DRB Application No.: 09 DRB - 70196 Project # 1006768  
 Project Name: Heights Reservoir  
 Agent: SUN-DEK Phone No.: \_\_\_\_\_

7. ~~Project# 1006768~~  
09DRB-70196 MINOR - PRELIMINARY/  
FINAL PLAT APPROVAL
- SURV-TEK INC agent(s) for SAN MATEO & LOMAS, LLC request(s) the above action(s) for all or a portion of Tract(s) 29A-1-A AND 291-1-B, **HEIGHTS RESERVOIR ADDITION** zoned CCR-3, located on LOMAS BLVD NE BETWEEN SAN MATEO BLVD NE AND MANZANO ST NE containing approximately 3.0486 acre(s). (K-17) **THE PRELIMINARY/FINAL PLAT WAS APPROVED.**

**DRB CASE NO/PROJECT NO: 1006768**

Development Review Board 8/29/07 Agenda Item #10  
Sketch Plat: Tract 29A-1, Heights Reservoir Addition

PLAT
OF
TRACT 29A-1-A, 29A-1-B AND 29A-1-C
HEIGHTS RESERVOIR ADDITION
(BEING A REPLAT OF TRACT 29A-1
HEIGHTS RESERVOIR ADDITION)
SEC. 23, T. 10N., R. 3E., N.M.P.M.
CITY OF ALBUQUERQUE, BERNALILLO COUNTY, NEW MEXICO
OCTOBER 2007

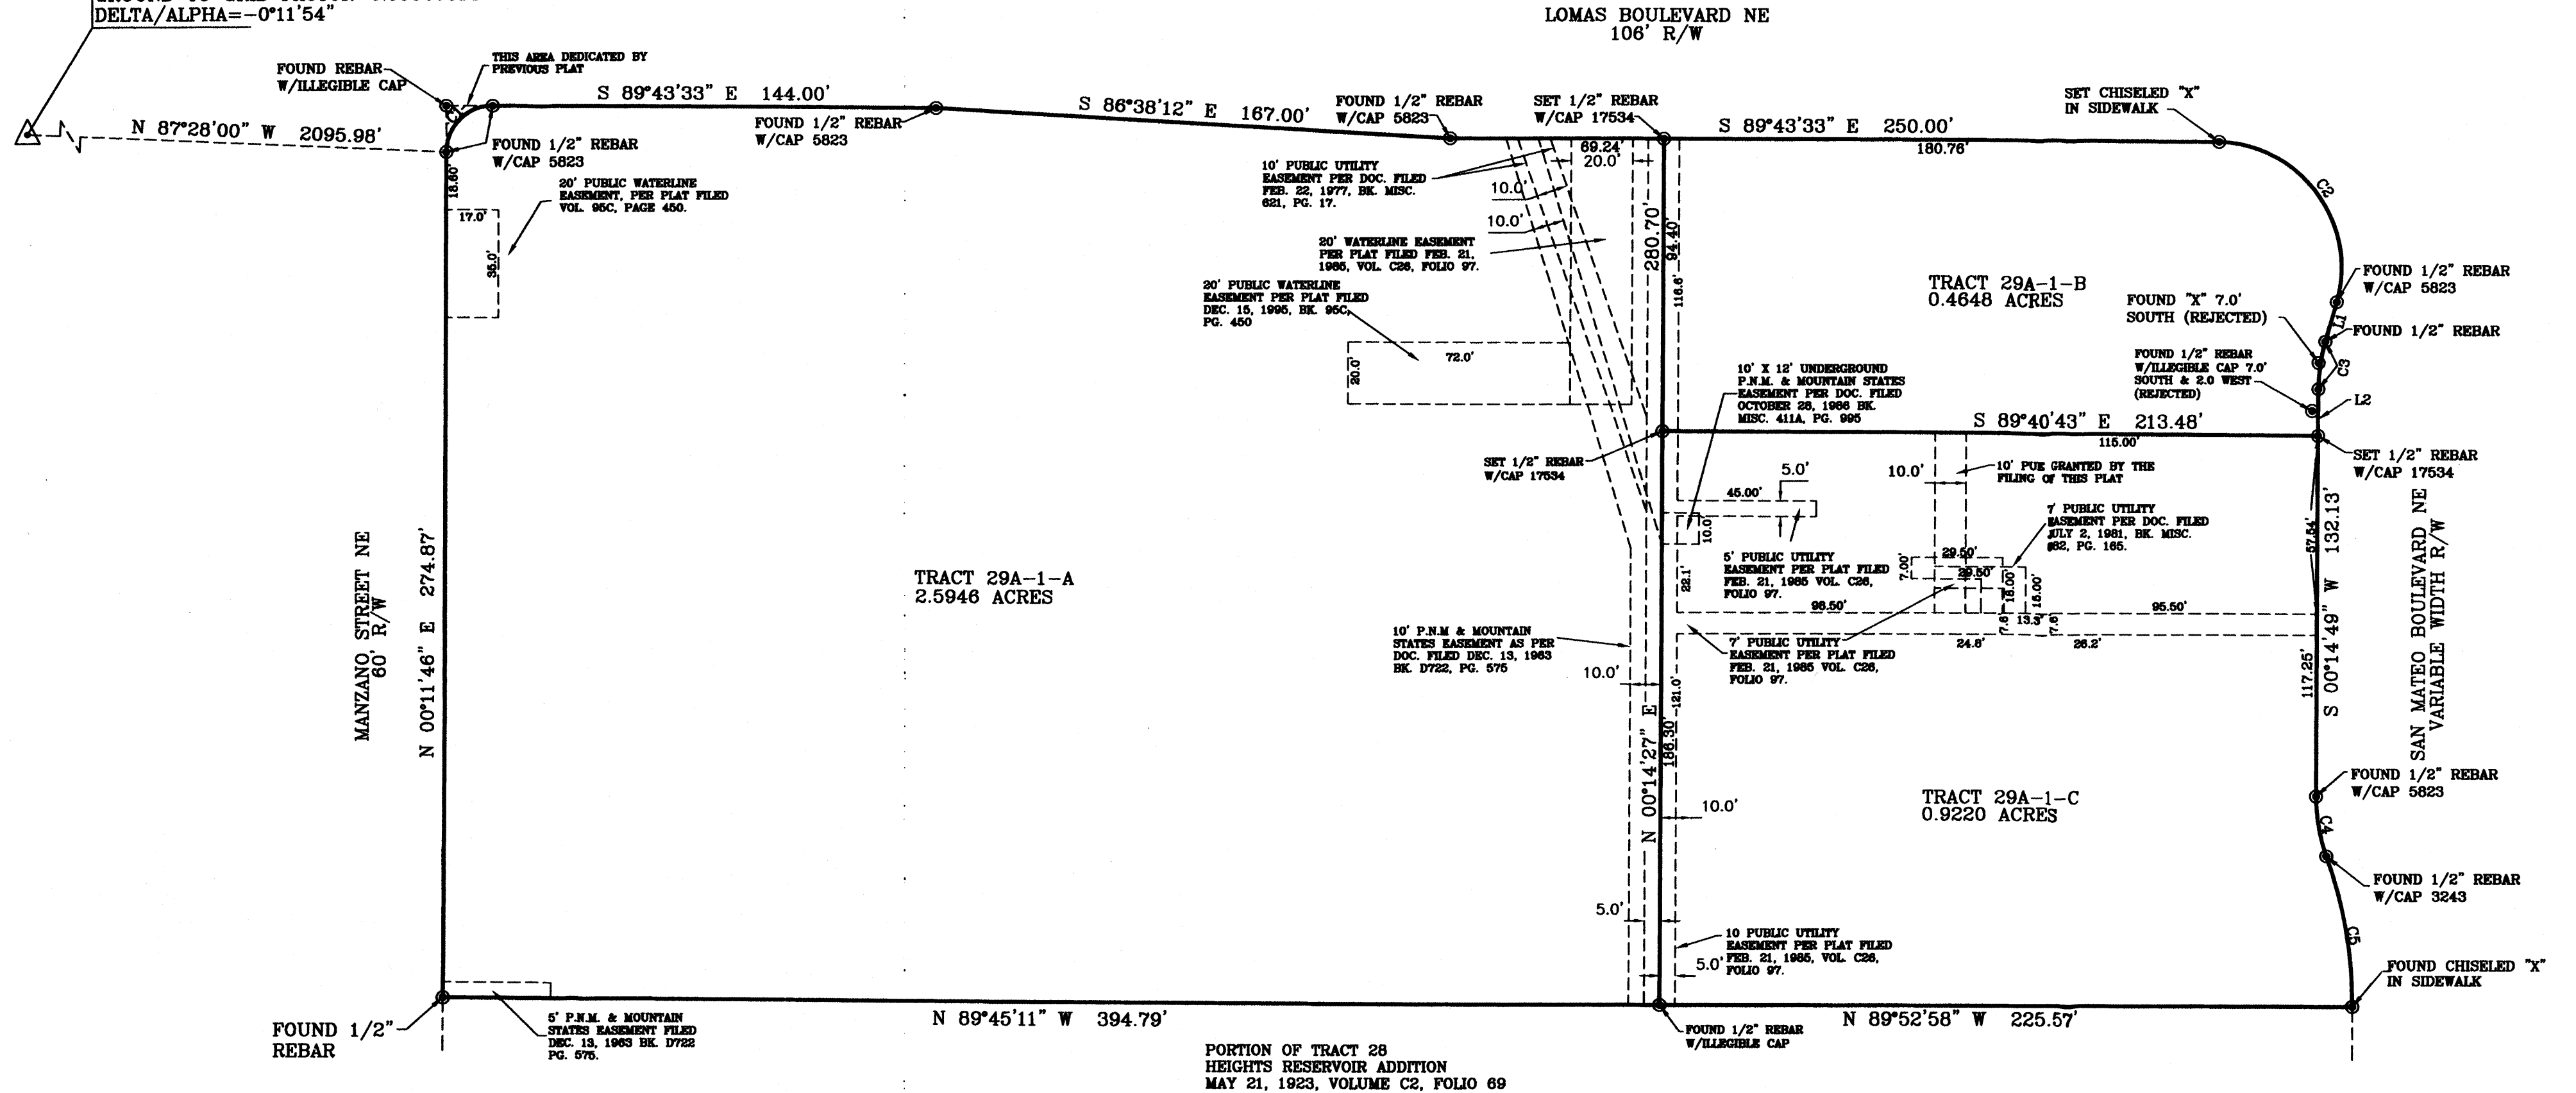
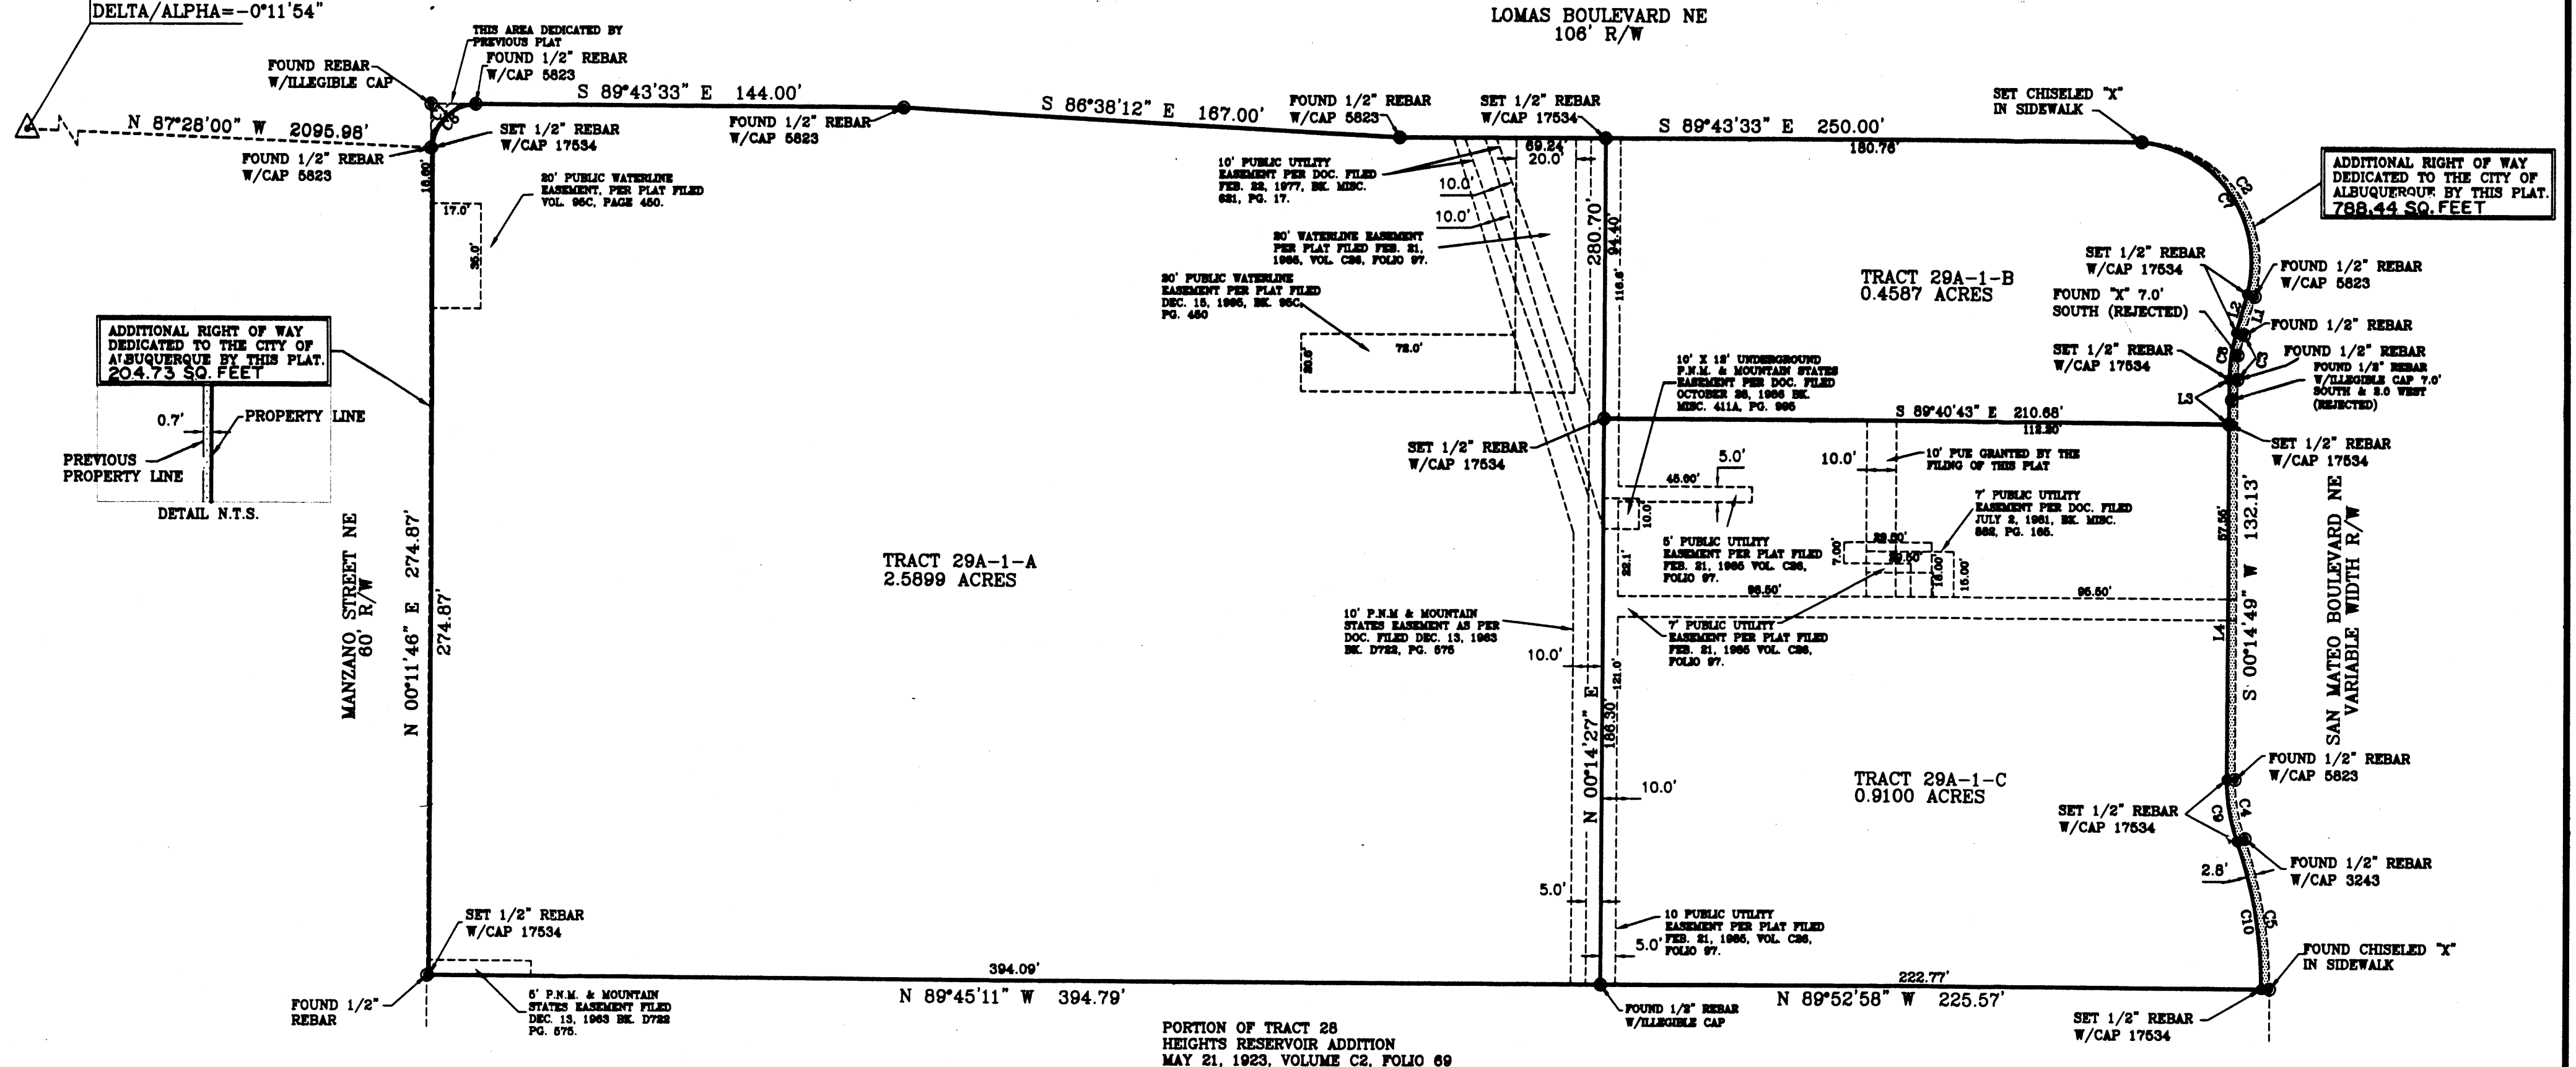
UTILITIES: where is existing building on San Mateo connected to water meter?  
what is correct address for San Mateo Building.

PLANNING (Last to sign): AGU dxg  
record plat  
provide 10 from face of curb along San Mateo and Marzan Street NE.
